Online Comment

Application H14-1170-25
Location G & J Peck Office, Offices & Premises Elsons Way Pinchbeck PE11 3JG
Proposal Change of use of existing building to Class E Research & Development, including new first floor installation and alterations consisting of new windows and doors, mechanical plant and PV panels.

GROUND FLOOR PLAN 1:100

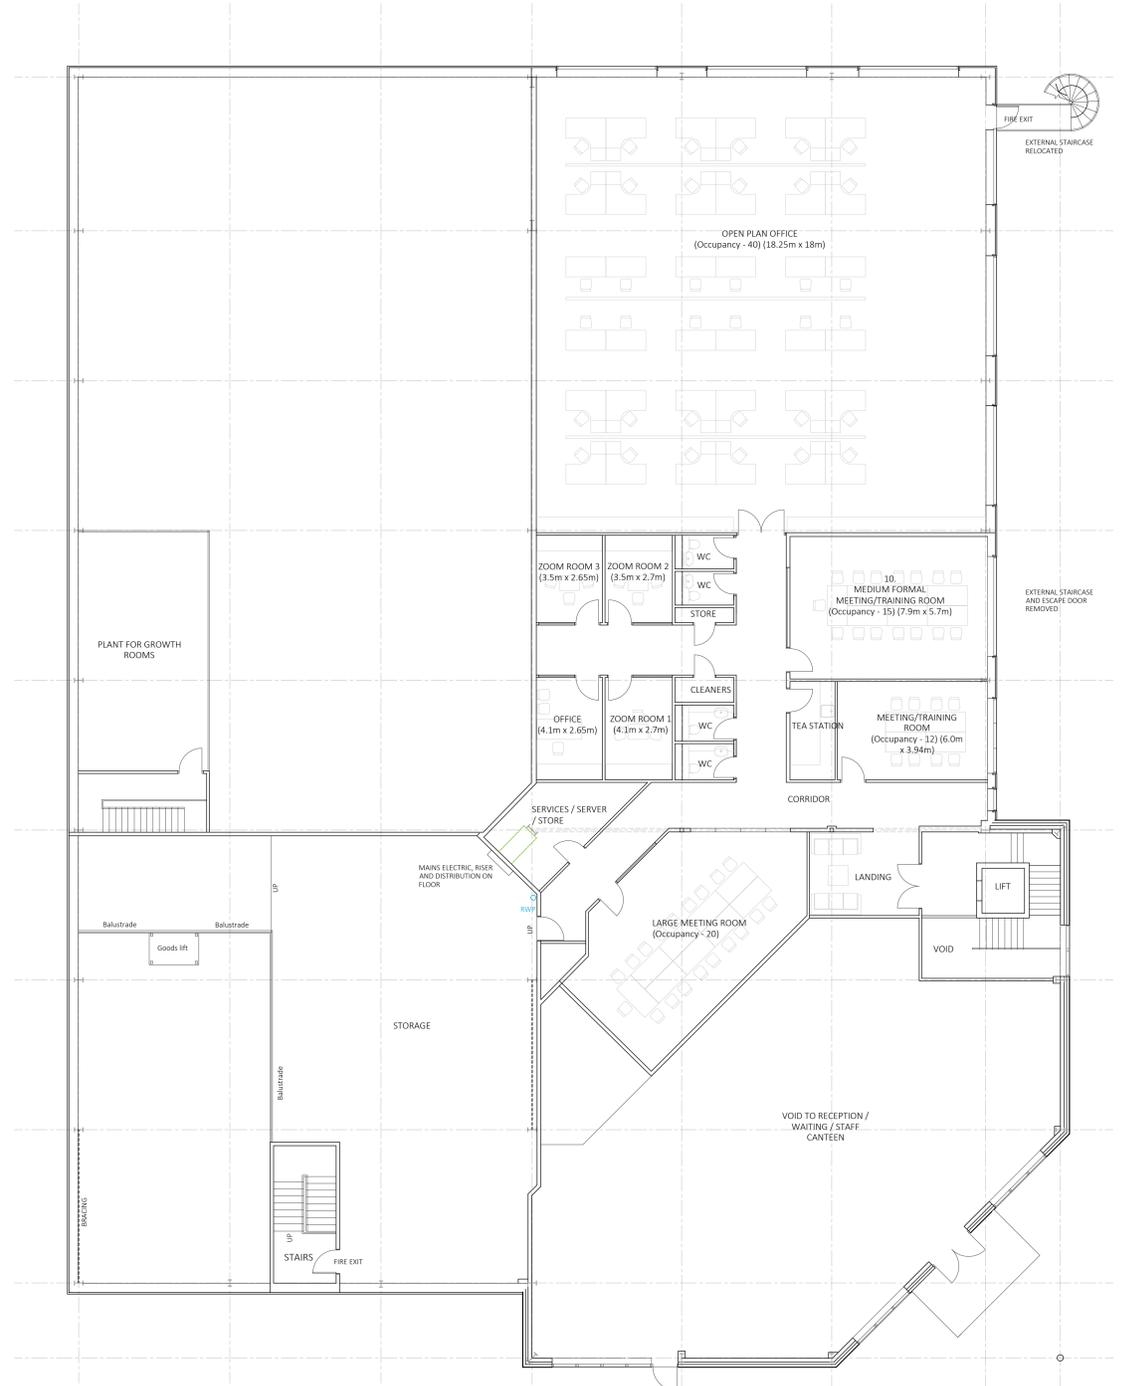
The application does not comply with Policy 36 of the Local Plan in relation to cycle parking because the application form and proposed site layout make no provision for staff or visitors to park bicycles. If permission is granted, please impose conditions which require details of the cycle store to be submitted to and approved by the Council before the development begins, and the approved details to be implemented and available for use before the development is occupied.
